# Memo

**To:** Lesley Collins, City of Ottawa Planning Department  
**From:** Carl Bray, Bray Heritage  
**Date:** Friday, June 6, 2014  
**RE:** 173 Huntmar Road: heritage component

**DRAWING**  
**SITE PLAN**

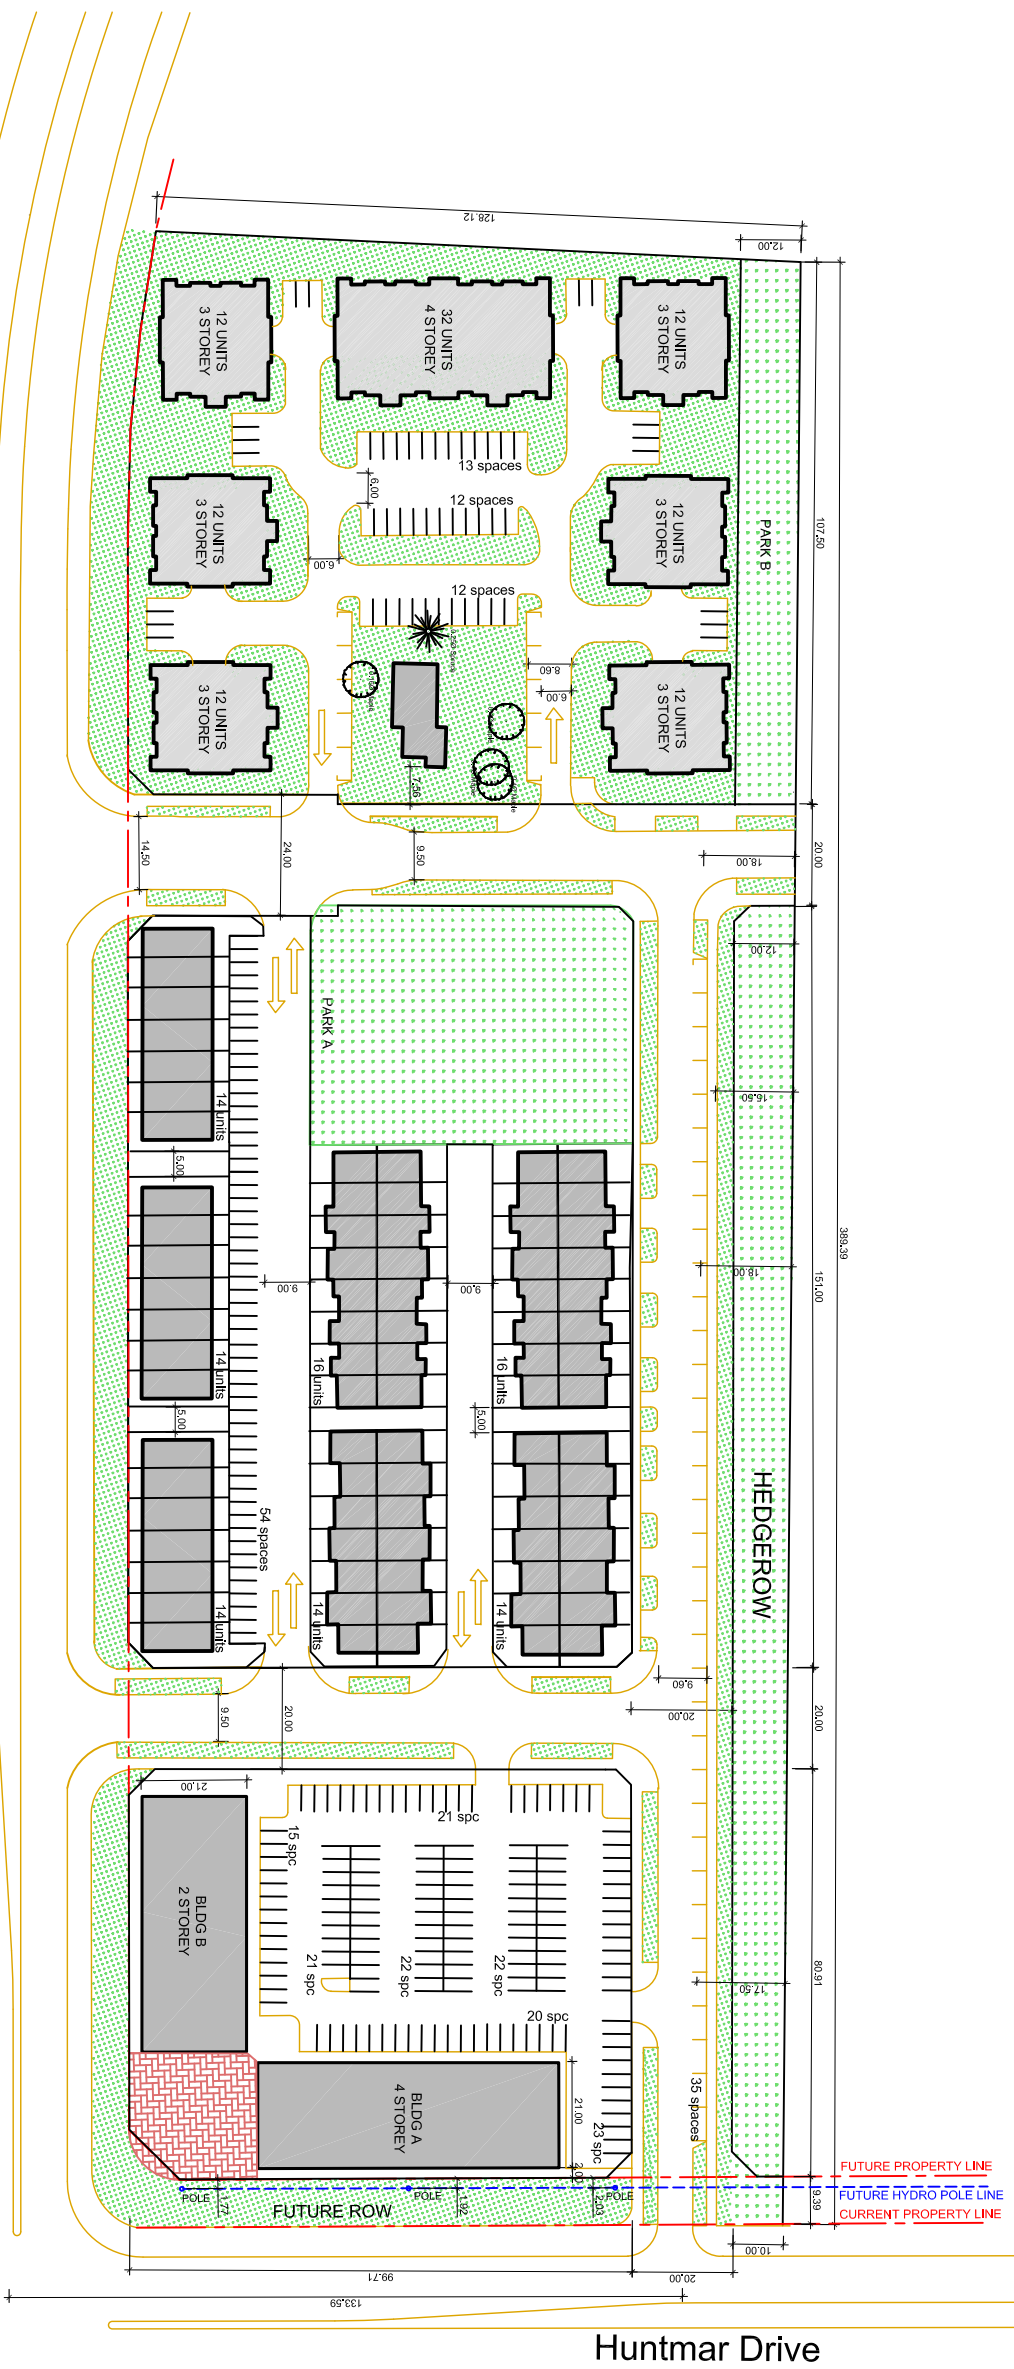
The existing building is shown as being severed from the rest of the development and located on a separate lot, with surface parking provided adjacent to the west wing on the north side. The proportions of the proposed lot appear to allow retention of some of the mature trees that currently surround the building and which the tree inventory prepared for the project indicate are worth keeping. Of particular importance are the existing trees to the east of the house, atop and east of the rise upon which the house is located. The

proposed north-south access road ROW parallels the east edge of the building lot. My understanding from conversations with the project planner is that the ROW can be moved eastwards slightly, if necessary, to ensure that there is an adequate buffer between the façade of the building and the new road.

In terms of the relationship of the existing house to the proposed development, I suggest that it would be advantageous to use this new lot as the core of an urban square in the western section of the development and to have new development face onto the square, as a way of highlighting the former farmhouse. The current site plan partially addresses this opportunity by showing the proposed townhouses west of the house and the apartments to the south as both having entrances facing the house. Further refinement of the design at the Site Plan stage will go further in accomplishing this goal.

Although they have not been identified as heritage attributes of the property, the mature coniferous trees bordering the north property line, as well as the mature specimens found in the hedgerows along the west and south boundaries, should be considered for retention. The northerly coniferous windbreak is not only a special visual feature, it can also function as a screen between the proposed residential development on this lot and whatever development is proposed for the lands to the north. Site grading for the adjacent development to the south should be designed so as to return to existing grades outside the root systems of the coniferous trees in order to ensure their retention.

In terms of its immediate context, providing the house with its own lot, upon which it appears can be retained much of the mature vegetation, allows full visual access to the house from all sides. The proposed new north-south and east-west access streets are also aligned to feature views of the house. In terms of the house lot, the parking location is acceptable and could also be accommodated behind the house, on the west side of its proposed lot. Accessibility can be easily handled from either parking location without having a negative impact on the building's heritage attributes, since there is sufficient space in which to locate an access ramp that would lead to the existing entrance on the north side of the house.

As for the remainder of the proposed site plan, the location of the proposed entrance drive off Huntmar Road, as well as the situation of the four apartment blocks, appears to allow retention of the coniferous windbreak along the north property line, east of the proposed north-south access road. Mature specimen trees along the south property line may be able to be retained within the right-of-way of the future north-south arterial road.
